REFUSAL OF PLANNING PERMISSION

APPLICATION NO. 2017/0167

Proposal Installation of security shutter to retail premise (Retrospective).

At 11 Market Street, Penistone, Sheffield, S36 6BZ

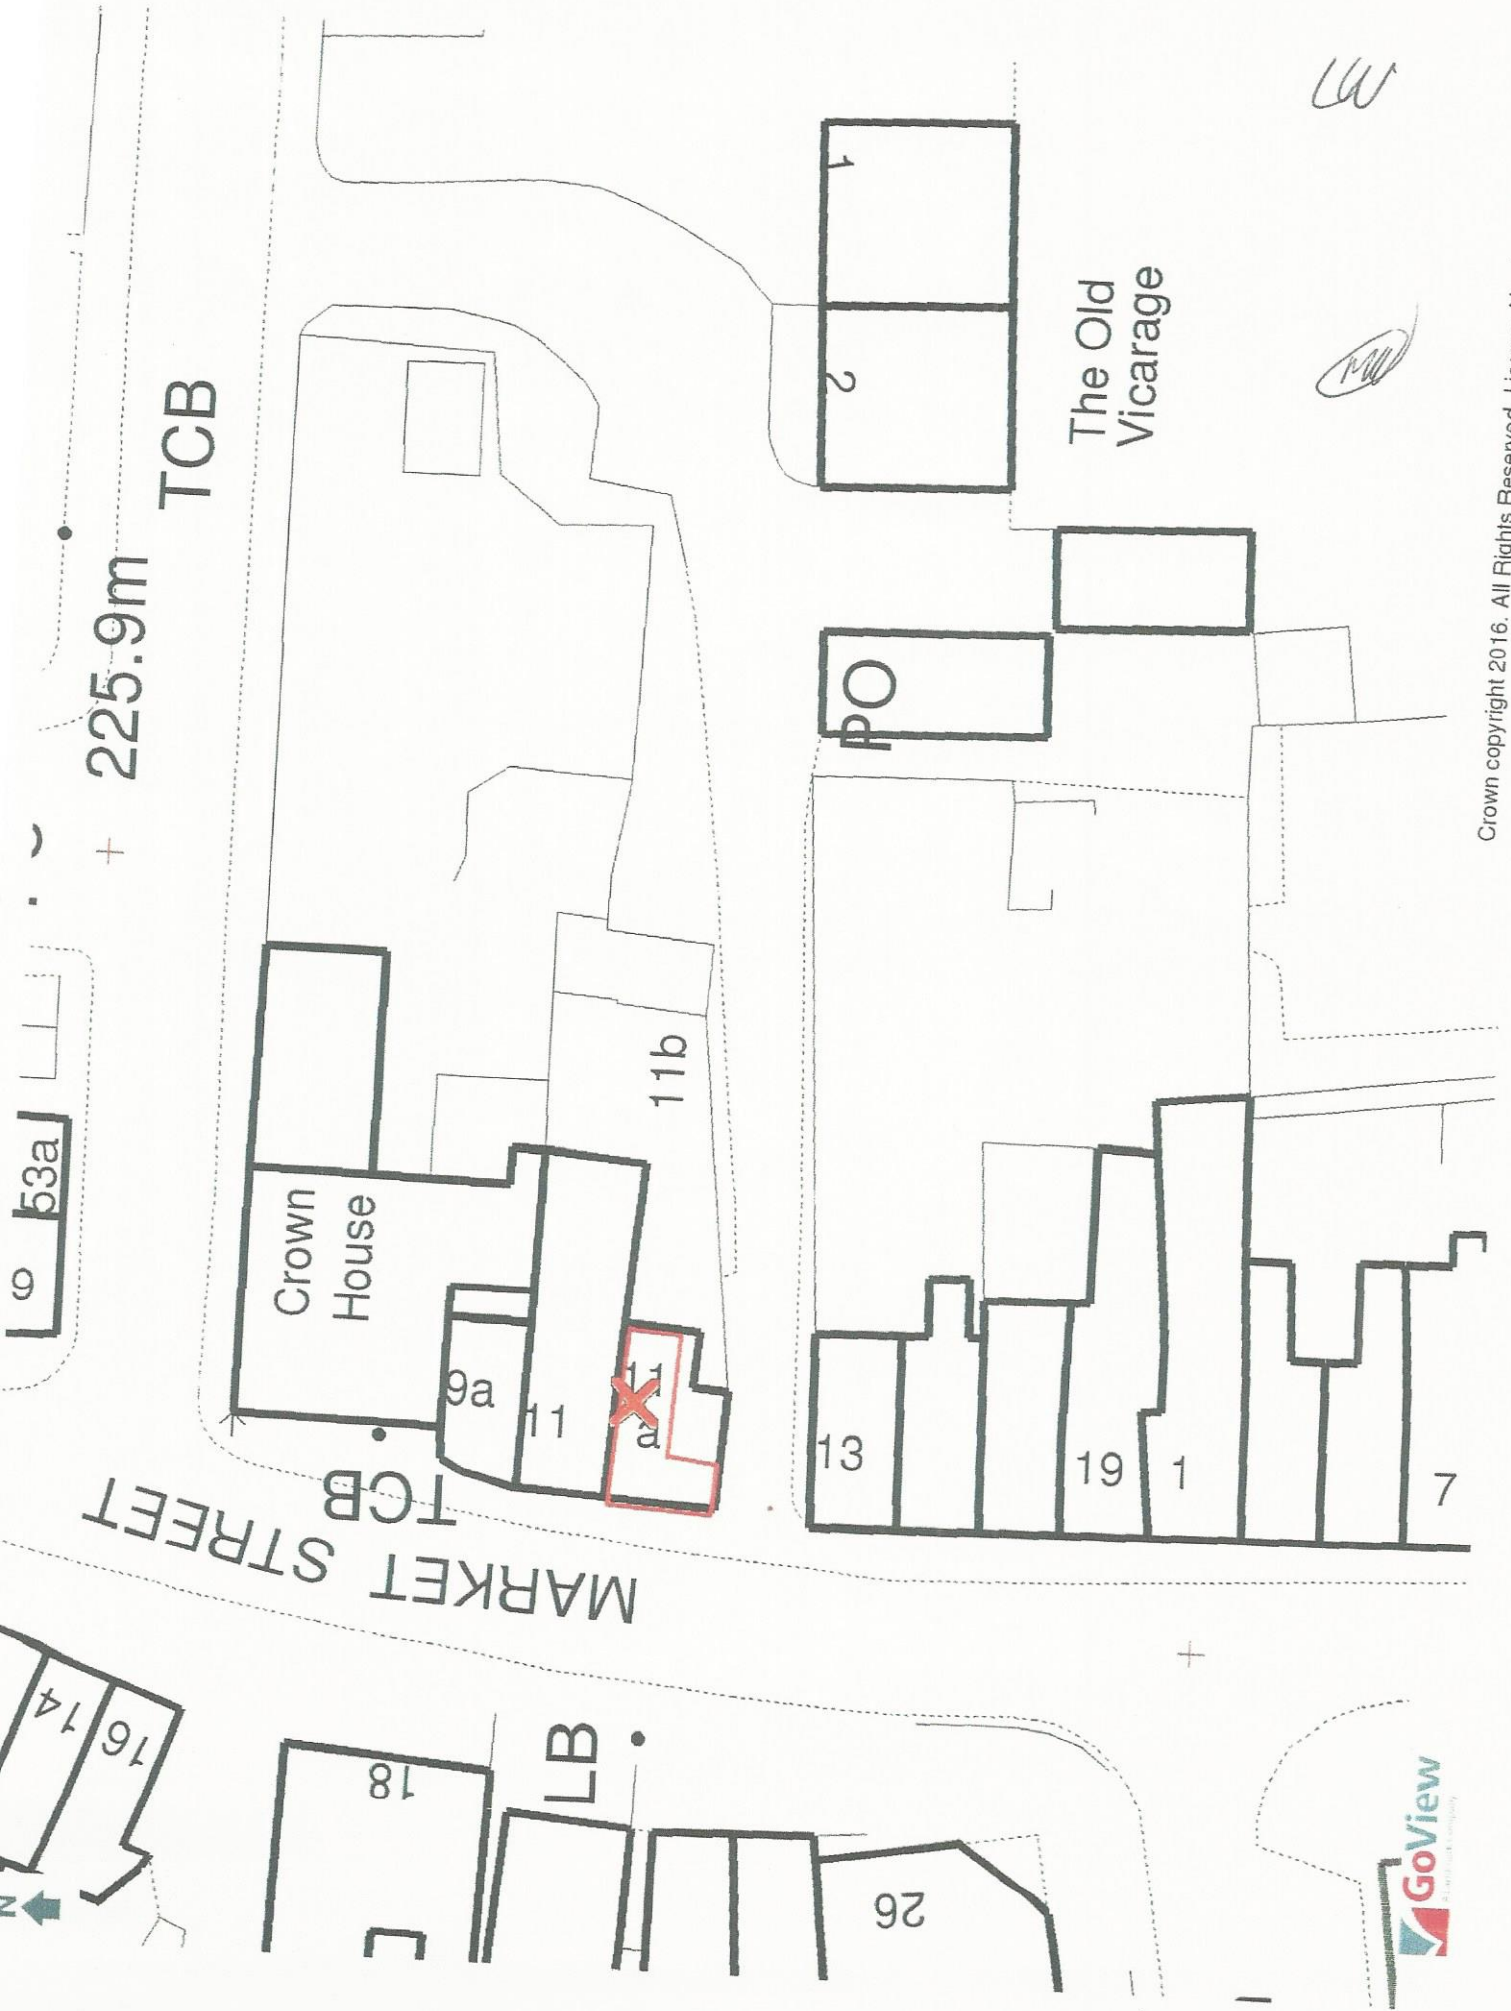
- 1 In the opinion of the Local Planning Authority, the combination of the external shutter box and shopfront, and the design and colours produce a bulky and awkward feature that is unsympathetic to the traditional nature of the building, erodes the setting of the historic core of the Conservation Area and the setting of nearby listed buildings and is therefore contrary to saved Policy BE6D of Unitary Development Plan, Core Strategy Policy 29: Design Principles, CSP30 - The Historic Environment, Supplementary Planning Document: Advertisements and Supplementary Planning Document: Shopfront Design.
